Our ref: AN/2022/132712
Your ref: EN010132

Date: 13 February 2024

Order Granting Development Consent for the West Burton Solar Project (EN010132) – applicant’s change request application.

Land Plans
 Sheet 7 of 10
 Revision C

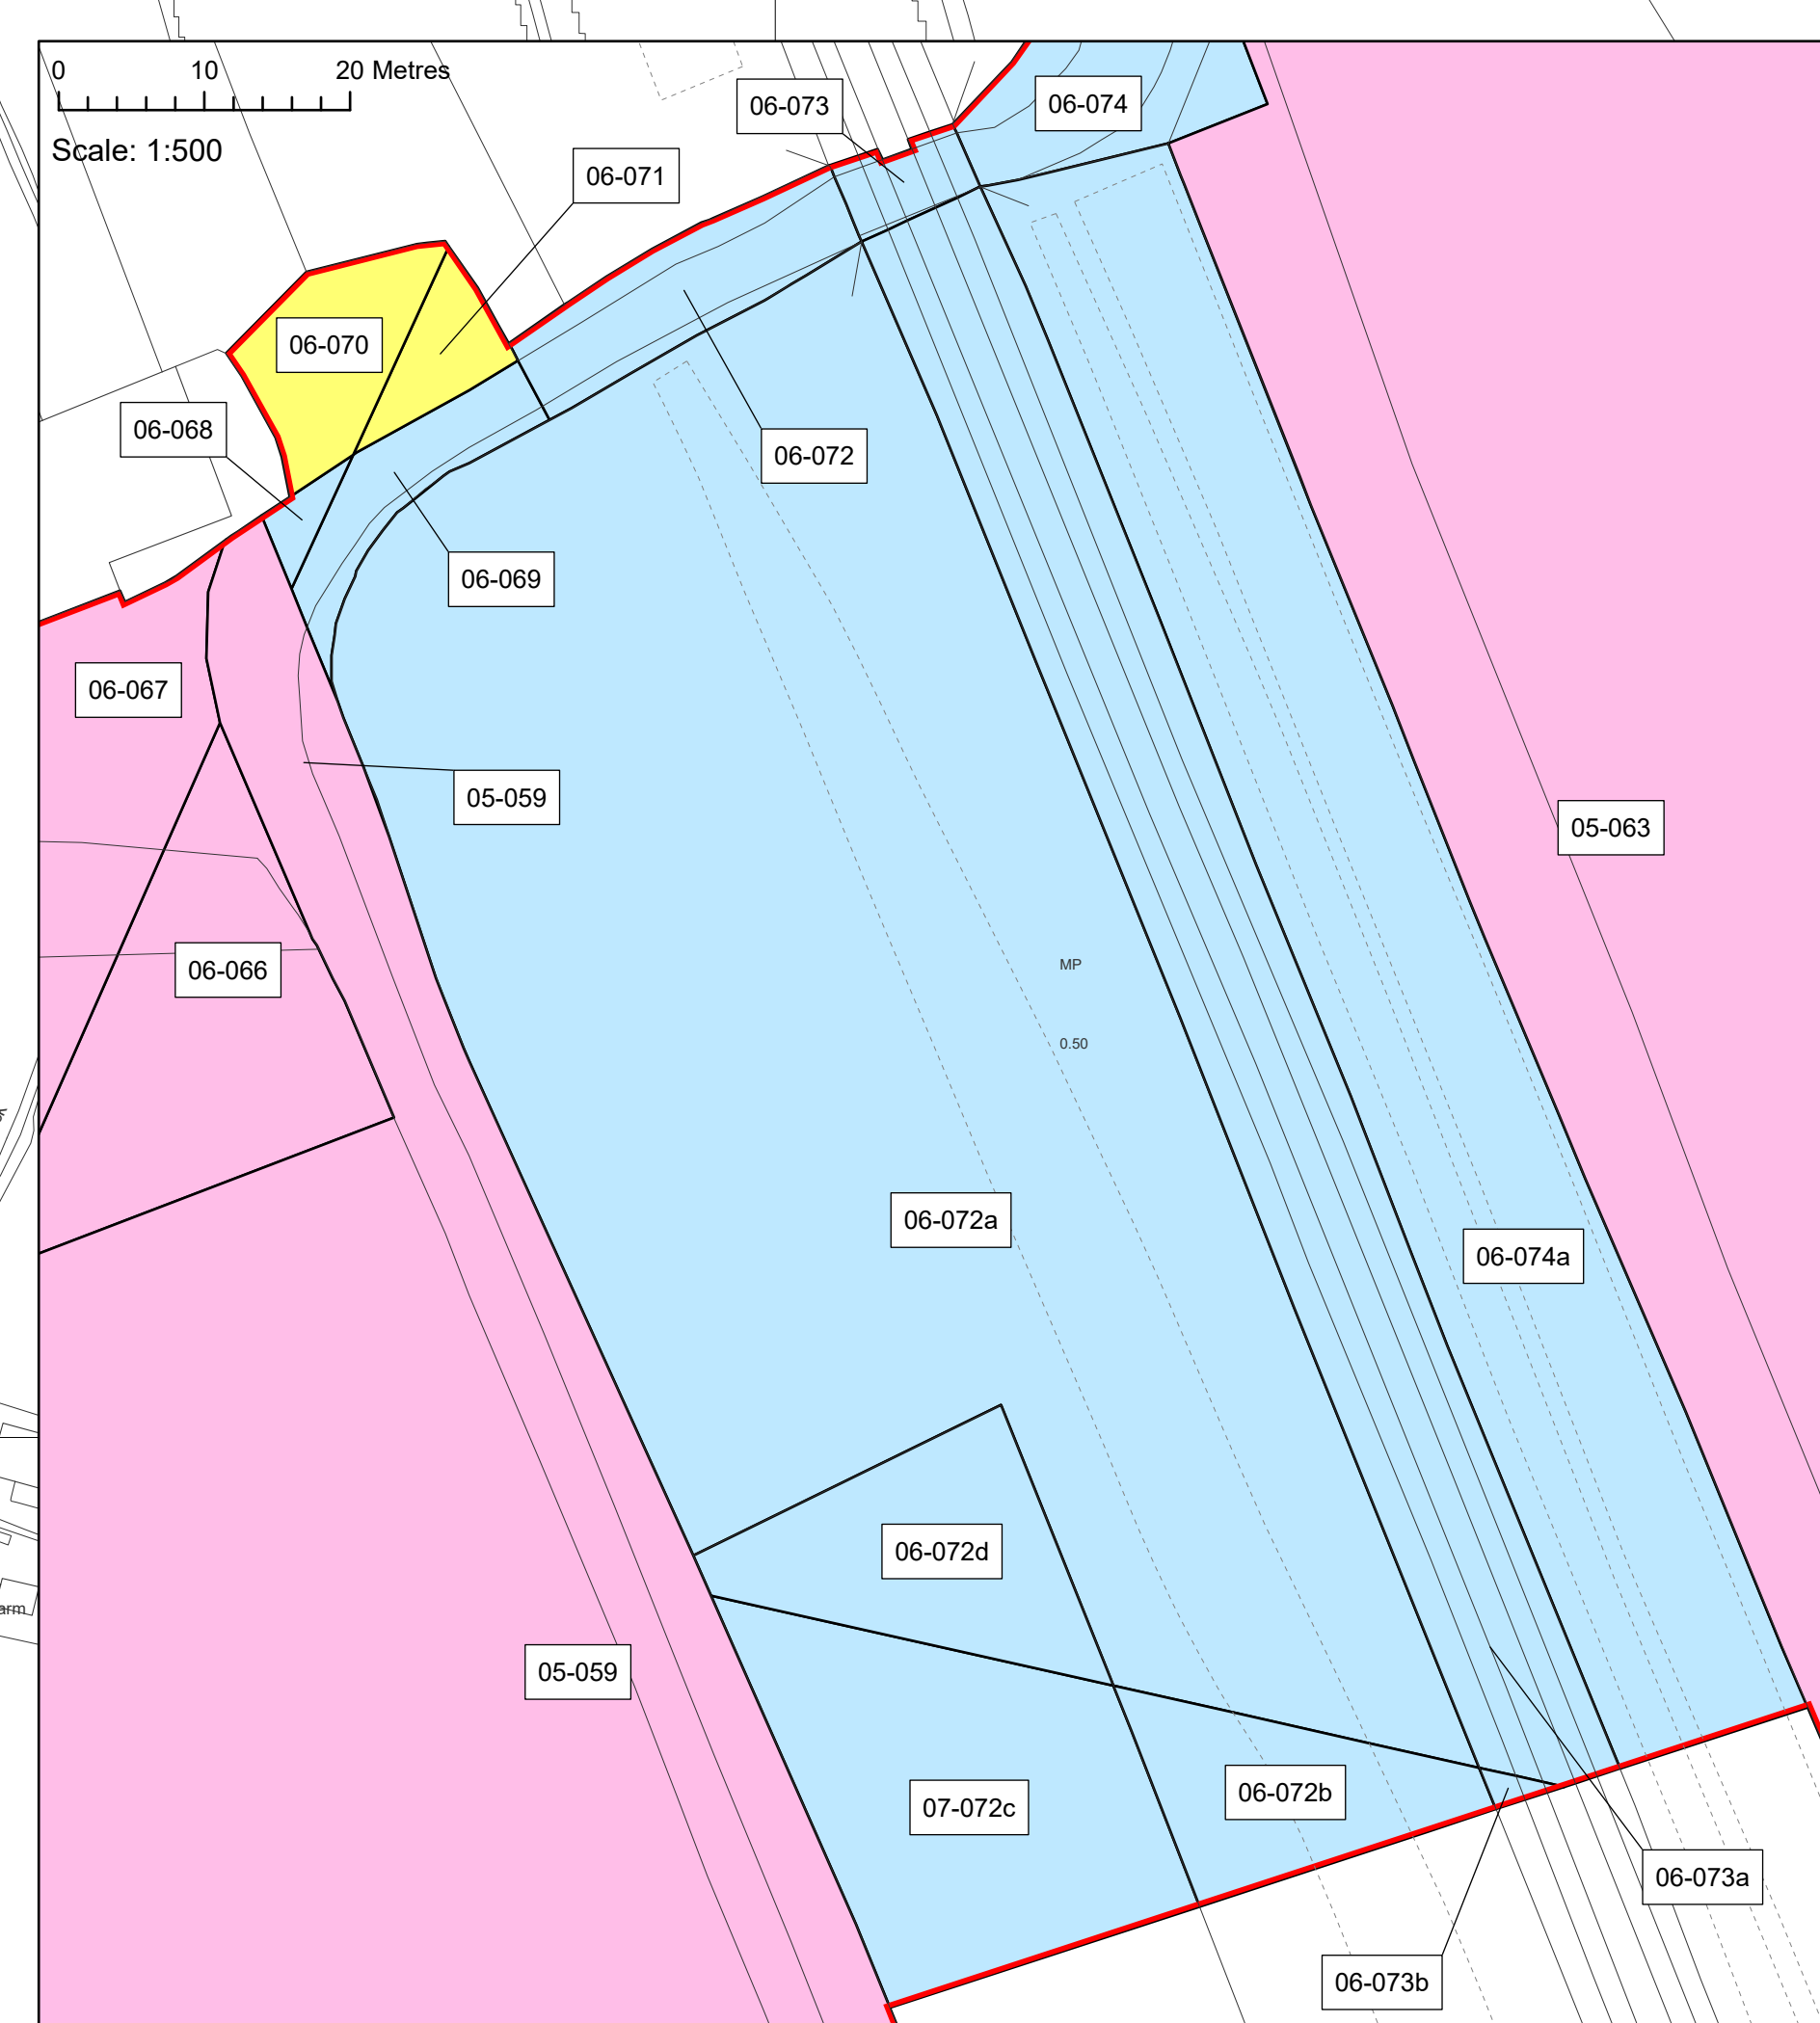
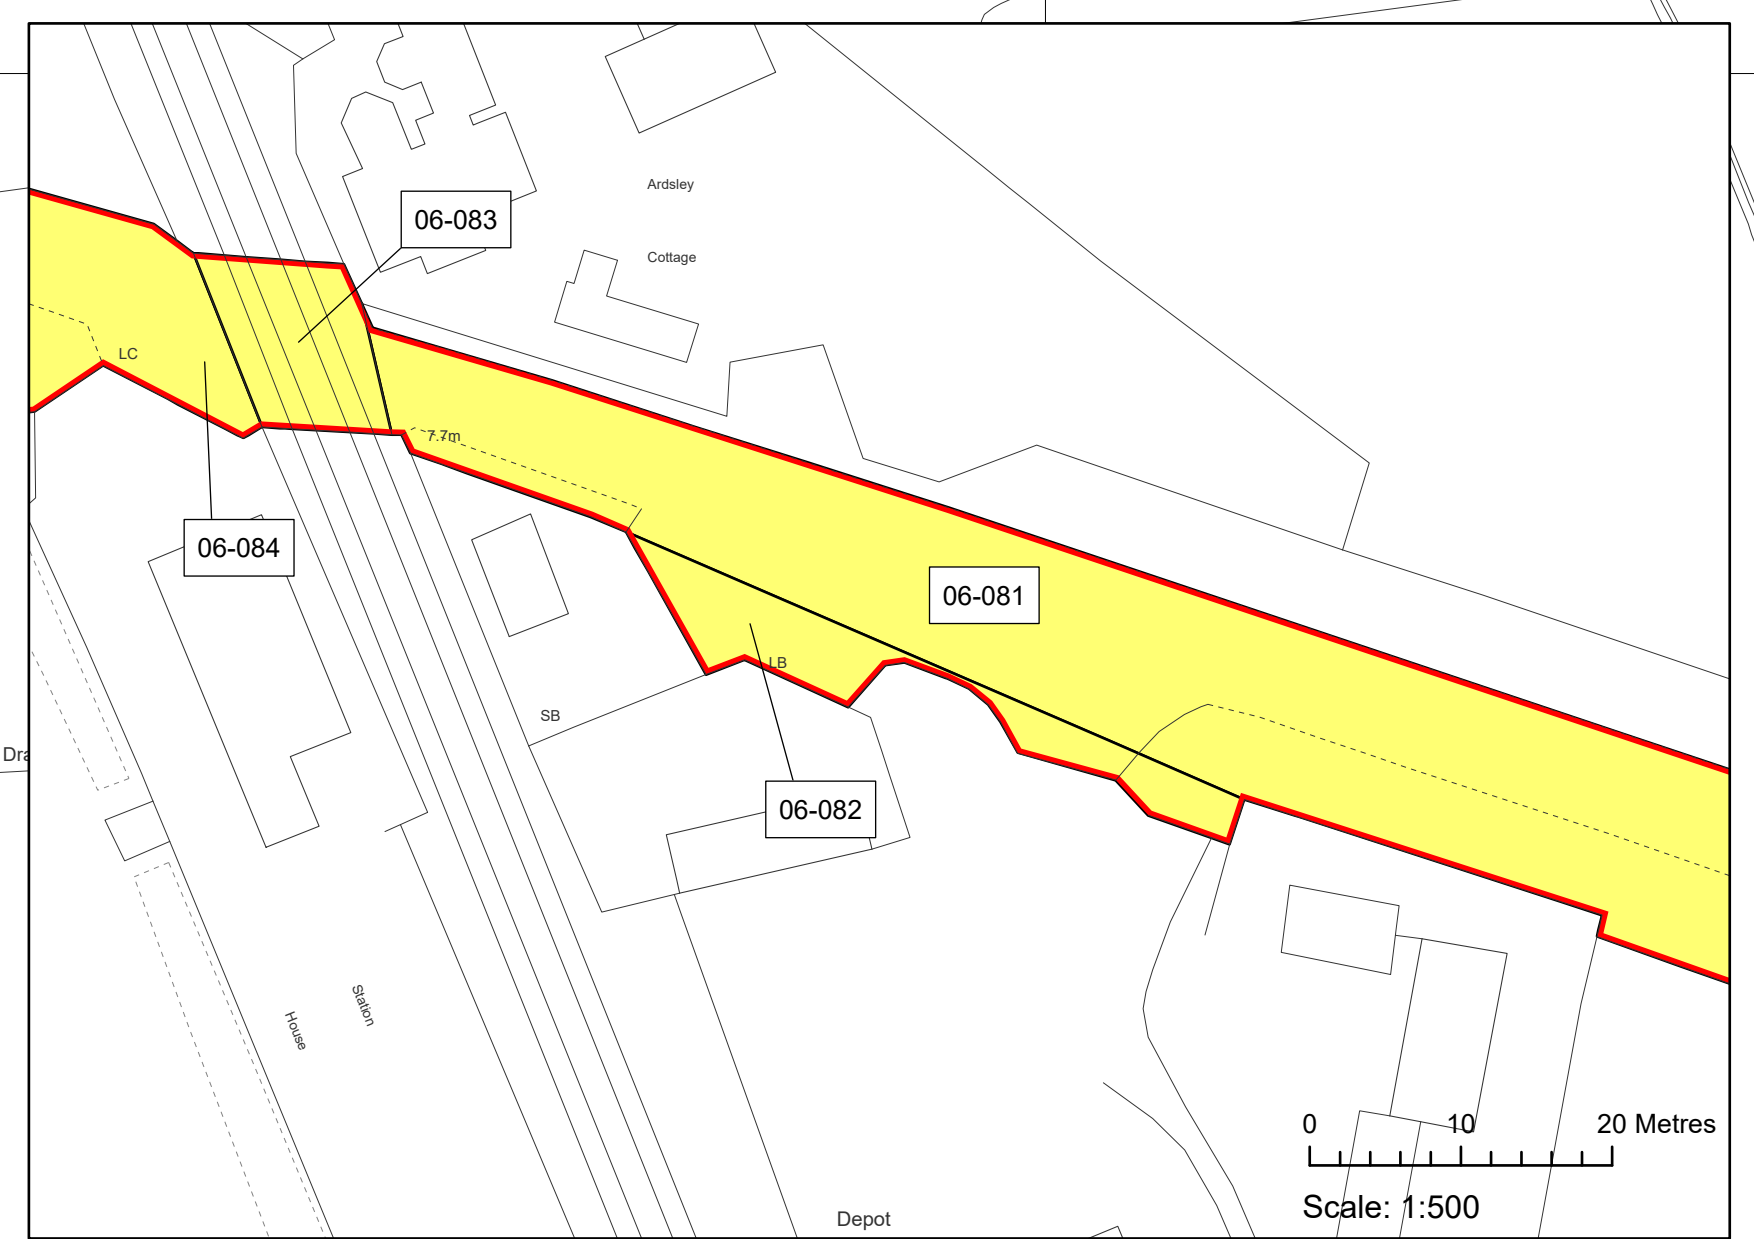
The proposed extension to the development scheme now passes very close to or even above an authorised landfill site. This is on sheet 7 of 10 of the Land Plan Revision B (January 2024)(Document CR1/WB2.2_B).

The details of the landfill site as are follows:

- West Bank of River Trent British Waterways, ref: EA/EPR/AP3297FZ, category A06 Landfill taking other wastes, NGR SK8270581479.

The developer must ensure that effects from and to this landfill are considered in the development of the scheme. Any interactions with the landfill must be discussed with the operator of the permit.
